Your ref CONCS/3/2007/0964
 Our ref TS/D3/07/964/MRN (VF)
 Date 27 November 2007

**TOWN AND COUNTRY PLANNING ACT 1990
 PROPOSED B1 OFFICE DEVELOPMENT (8746SQM) REVISION TO
 APPROVED MATTERS APPLICATION
 BARROW BROOK BUSINESS PARK BARROW
 FOR PAPIILLION PROPERTIES LTD**

Schematic Layout 5

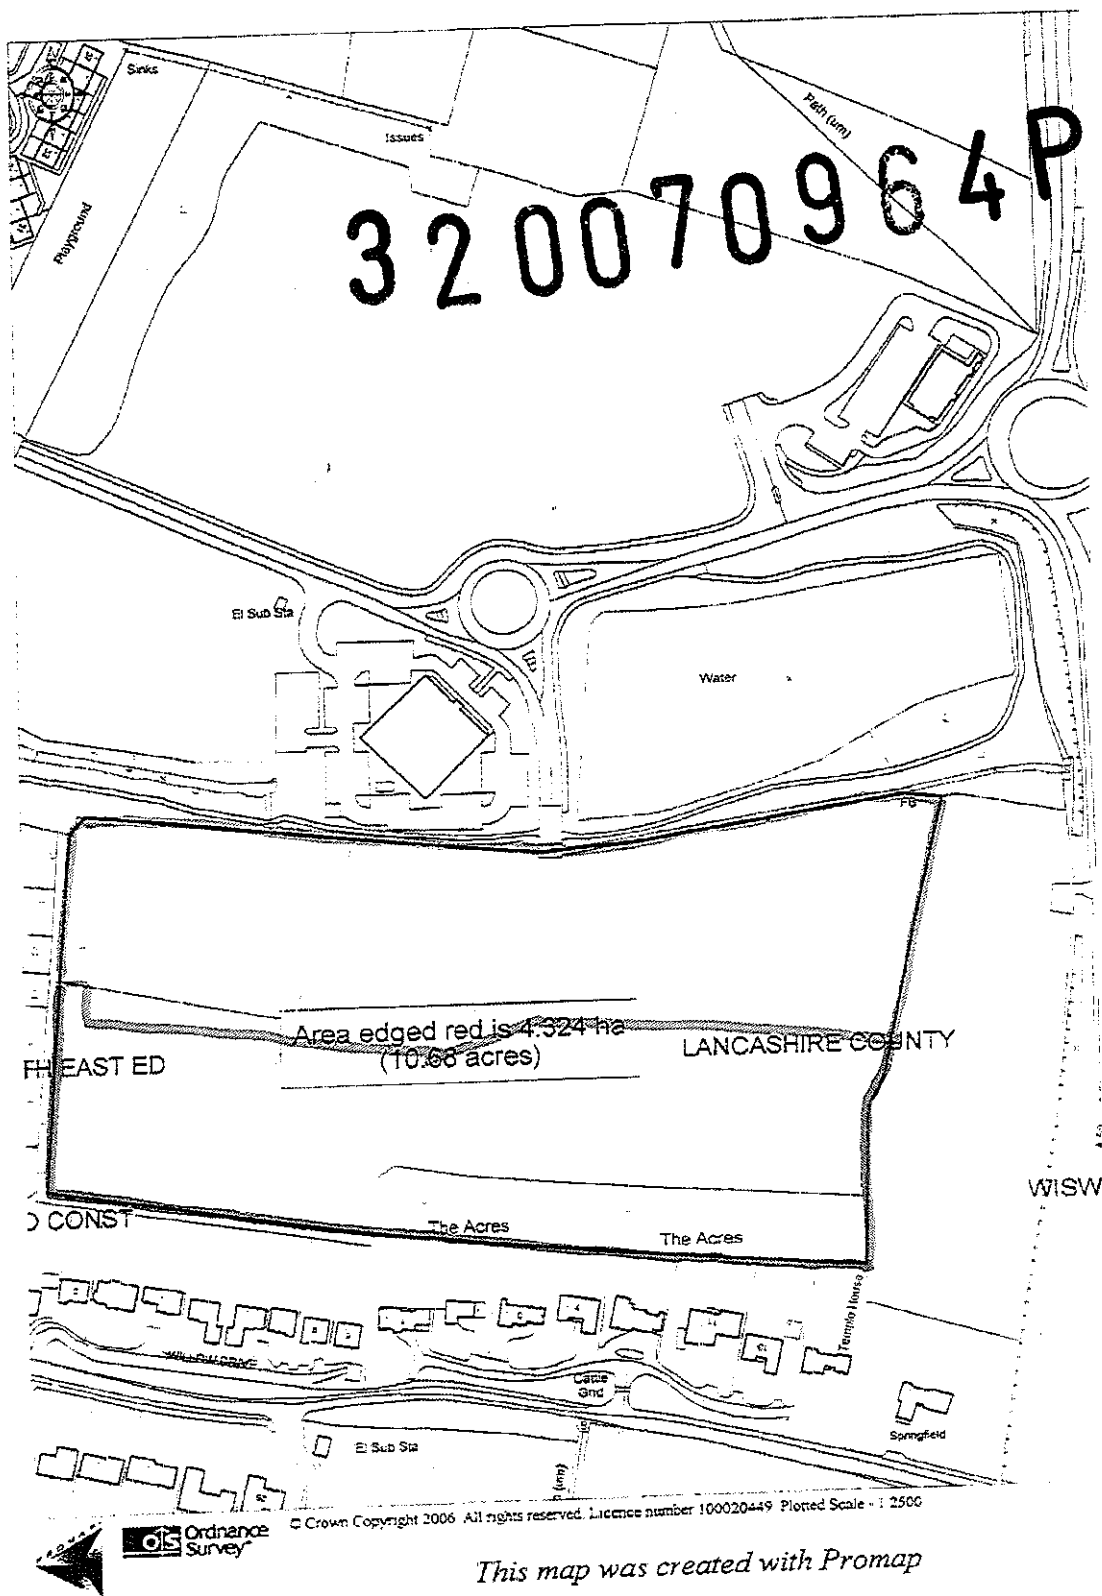
1. All proposed highway works must be constructed in accordance with the LCC Specification for Estate Roads and be to full adoption standards with 2m wide footways along both sides of the road even if the developer intends the roads to be private.
2. Where shown on the scheme drawings, the footway is not always continuous and they can narrow significantly or are omitted, where the footway runs along the back of car parking spaces.
3. The developer should also be advised of the need to contact Alex Fogg of our Bridges Section on 01772-534624 for advice regarding adoption requirements of the structures over the watercourse and reservoir overflow to the south of the internal roundabout.

5. The application indicates that there should be 331 car parking spaces on site, of which 33 are designated mobility spaces. The site layout shows a total of 623 spaces.

7. For the proposed B1 use, under Phase 1 the maximum car parking total would be 292 spaces and this would rise to a maximum of 374 following completion of Phase 2. The internal parking layout of 623 spaces will therefore require a comprehensive review.

9. The open car parking layout produces parking islands surrounded by circulating traffic and this is clearly to the potential detriment of pedestrians. In addition, when moving from their vehicles to their destination, pedestrians will be passing through rows of parked vehicles. A series of clearly defined pedestrian routes should be introduced, providing a secure route to the main building entrances.
